East Anglia TWO Offshore Wind Farm

**Natural England's Terrestrial Ecology Update and Comments to Documents [REP3-031,
REP4-004, REP4-005, REP4-015 and REP4-043]**

Planning Inspectorate Reference: EN010078

3rd February 2021

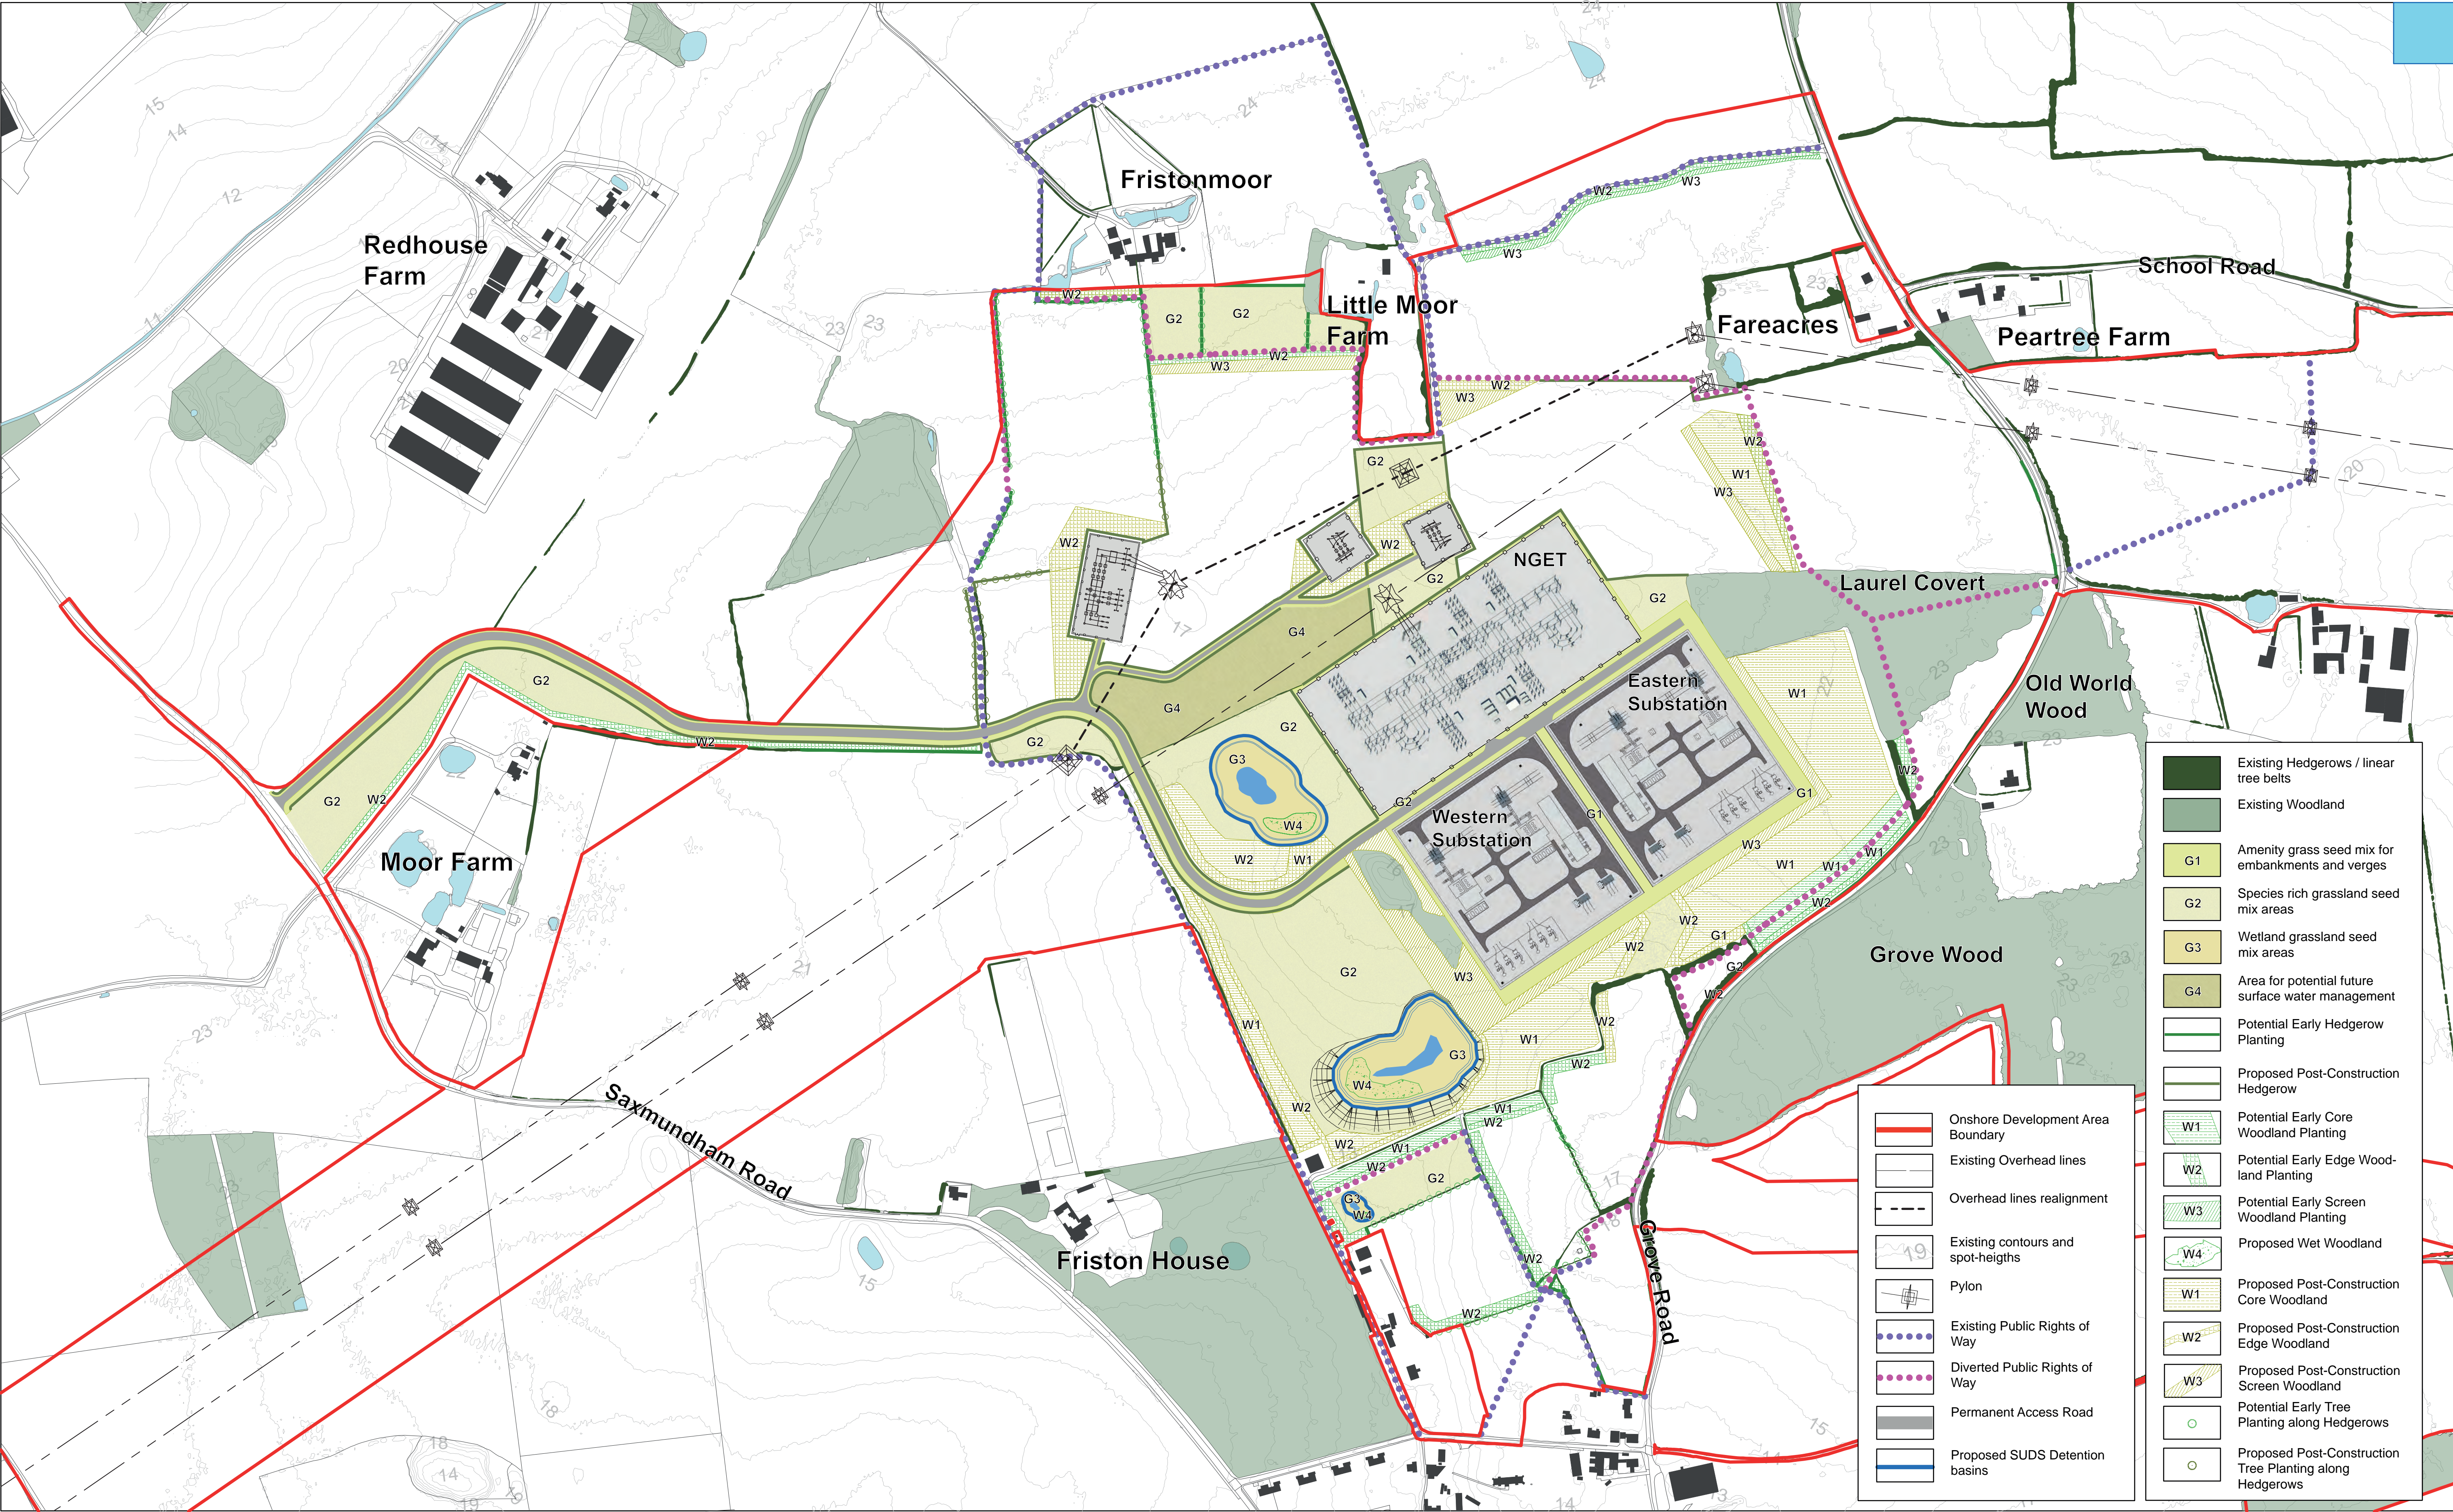
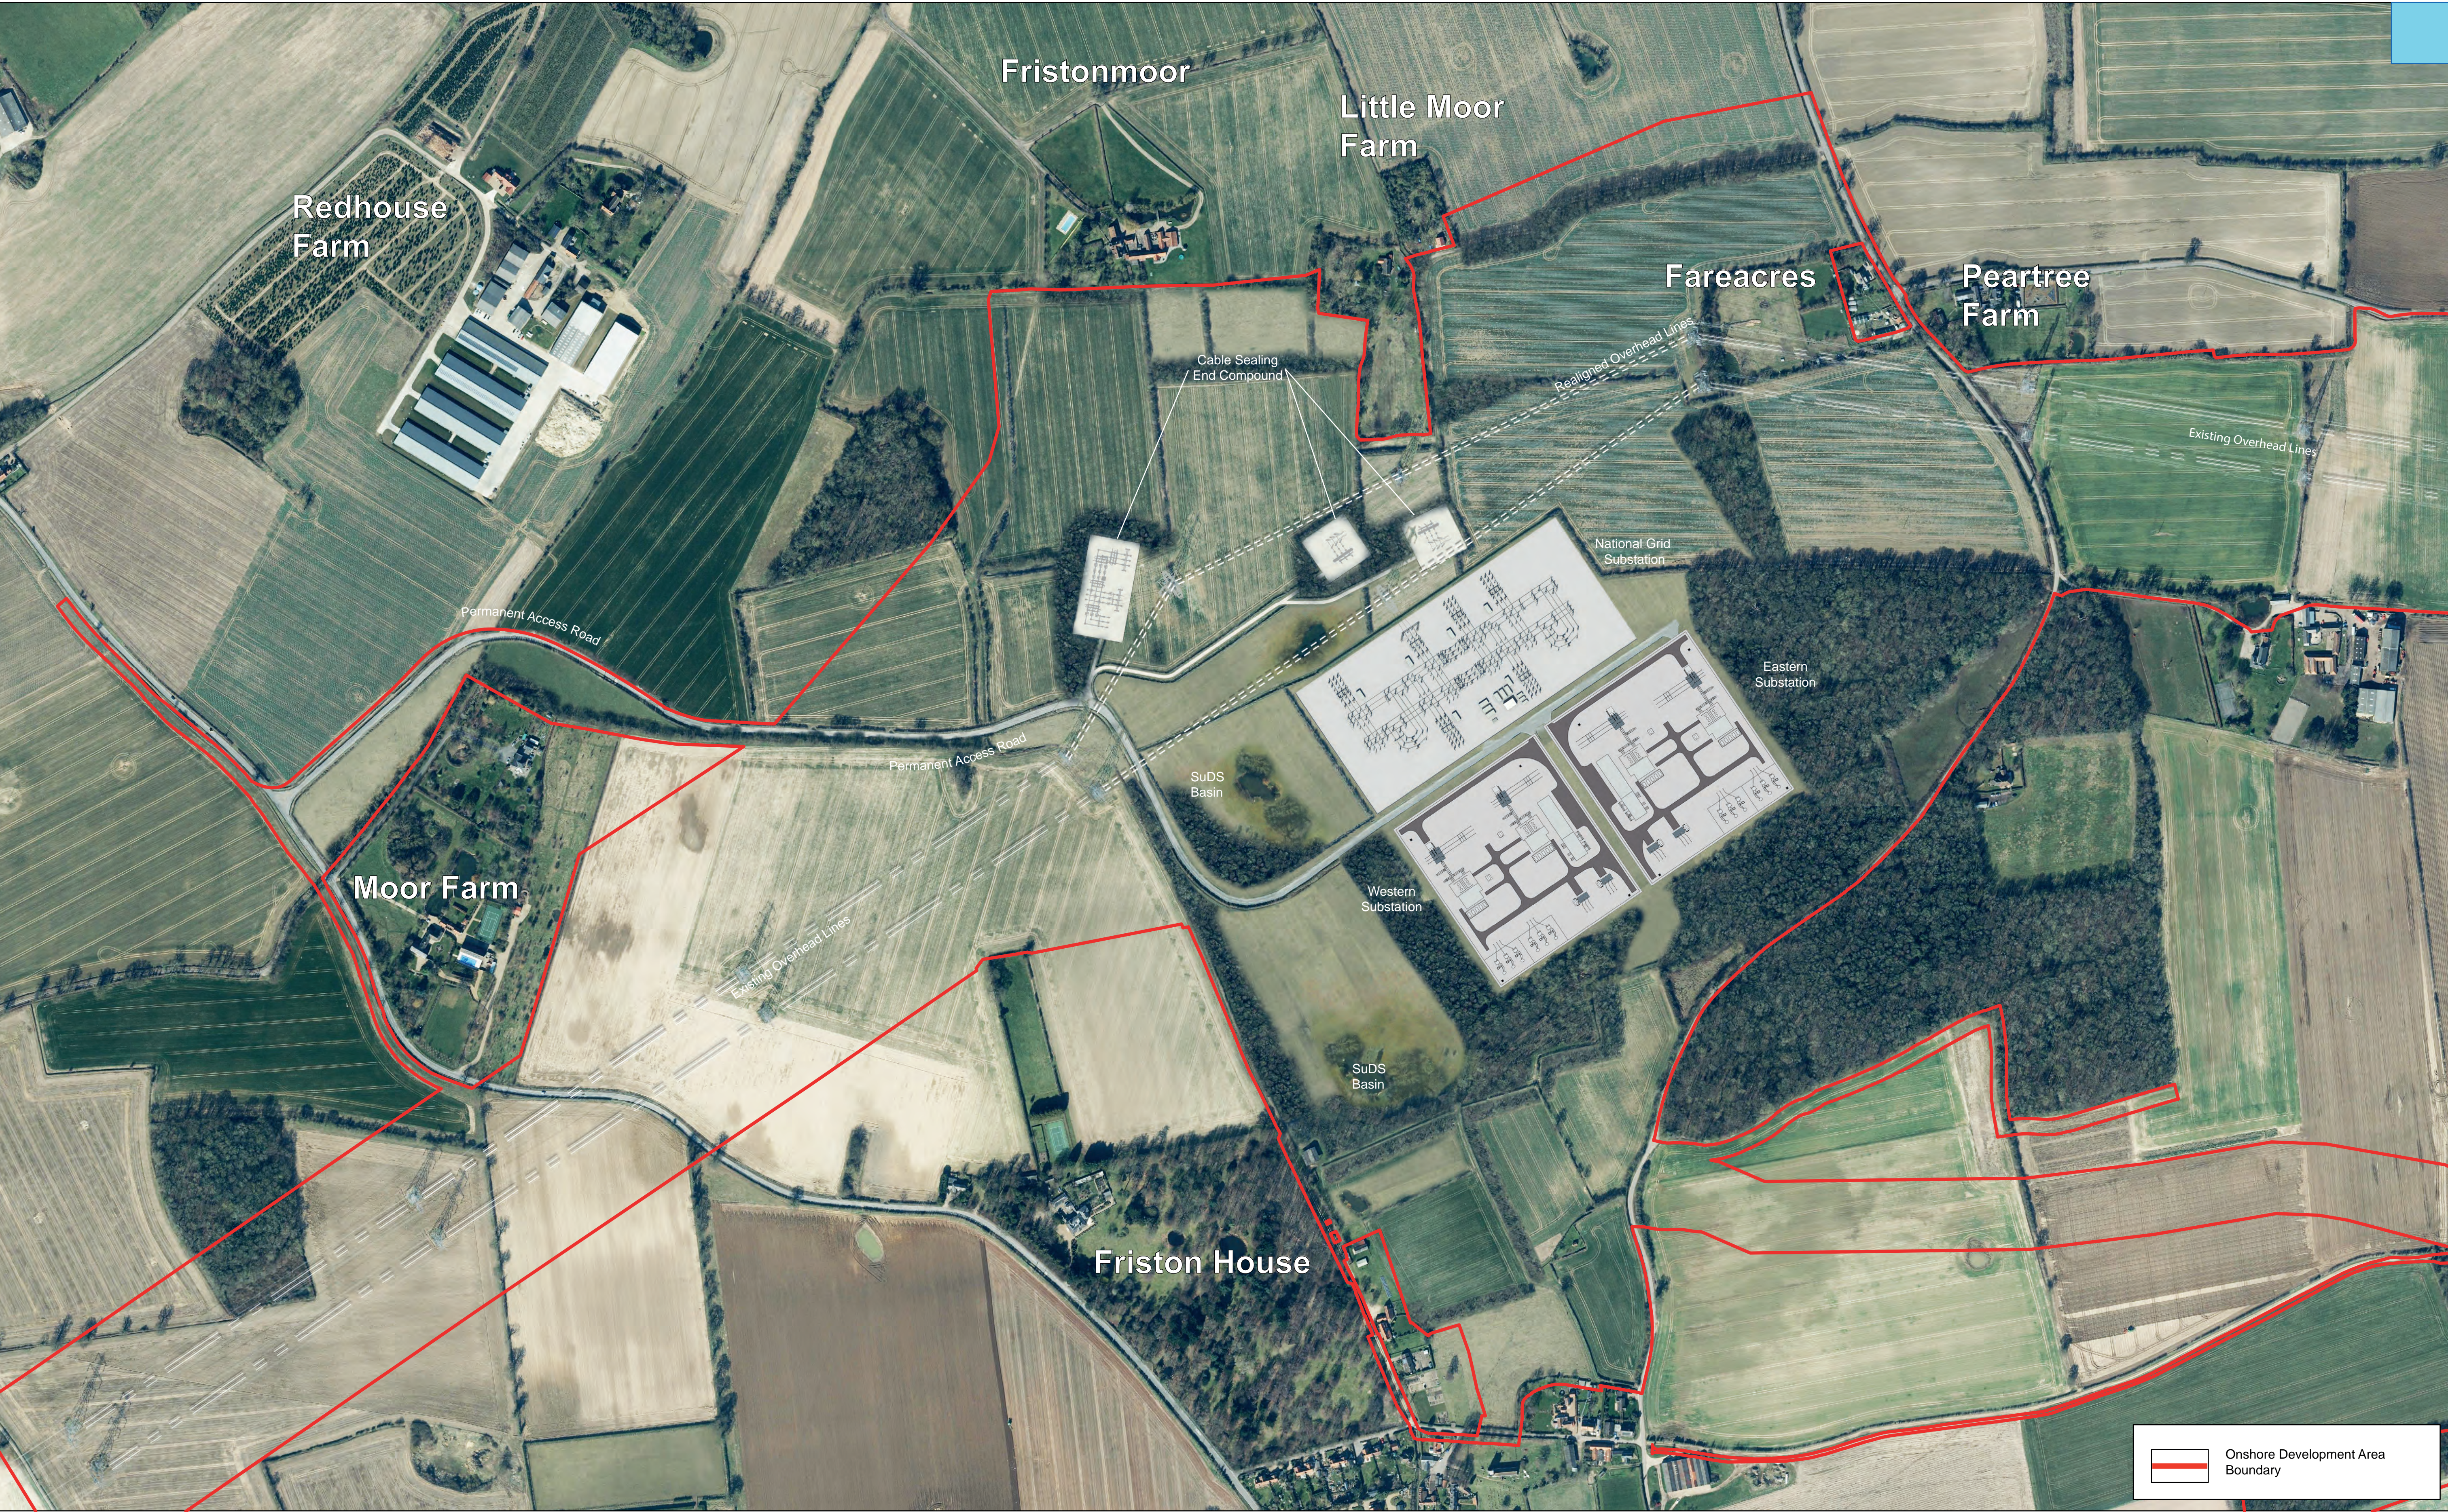
12. We welcome the woodland retention, additional woodland planting and the proposed increased density of tree planting outlined in 45 (3.1.4) Amendments to the OLMP. However we are now aware that there is an area of deciduous woodland, which is Priority Habitat, adjacent to the Hundred river crossing (see comments in paras 7 and 8 above). Natural England is surprised this habitat has not been picked up during the phase one habitat survey, or included within the mitigation plans, and request that this habitat is assessed and added to all relevant documentation.

30. Natural England have no specific comments regarding this plan other than to remind the Applicant that the Priority Habitat next to the Hundred River Crossing is likely to need to be included within this plan. See comments regarding the proposed mitigation and enhancement in our comments regarding the OLEMS.
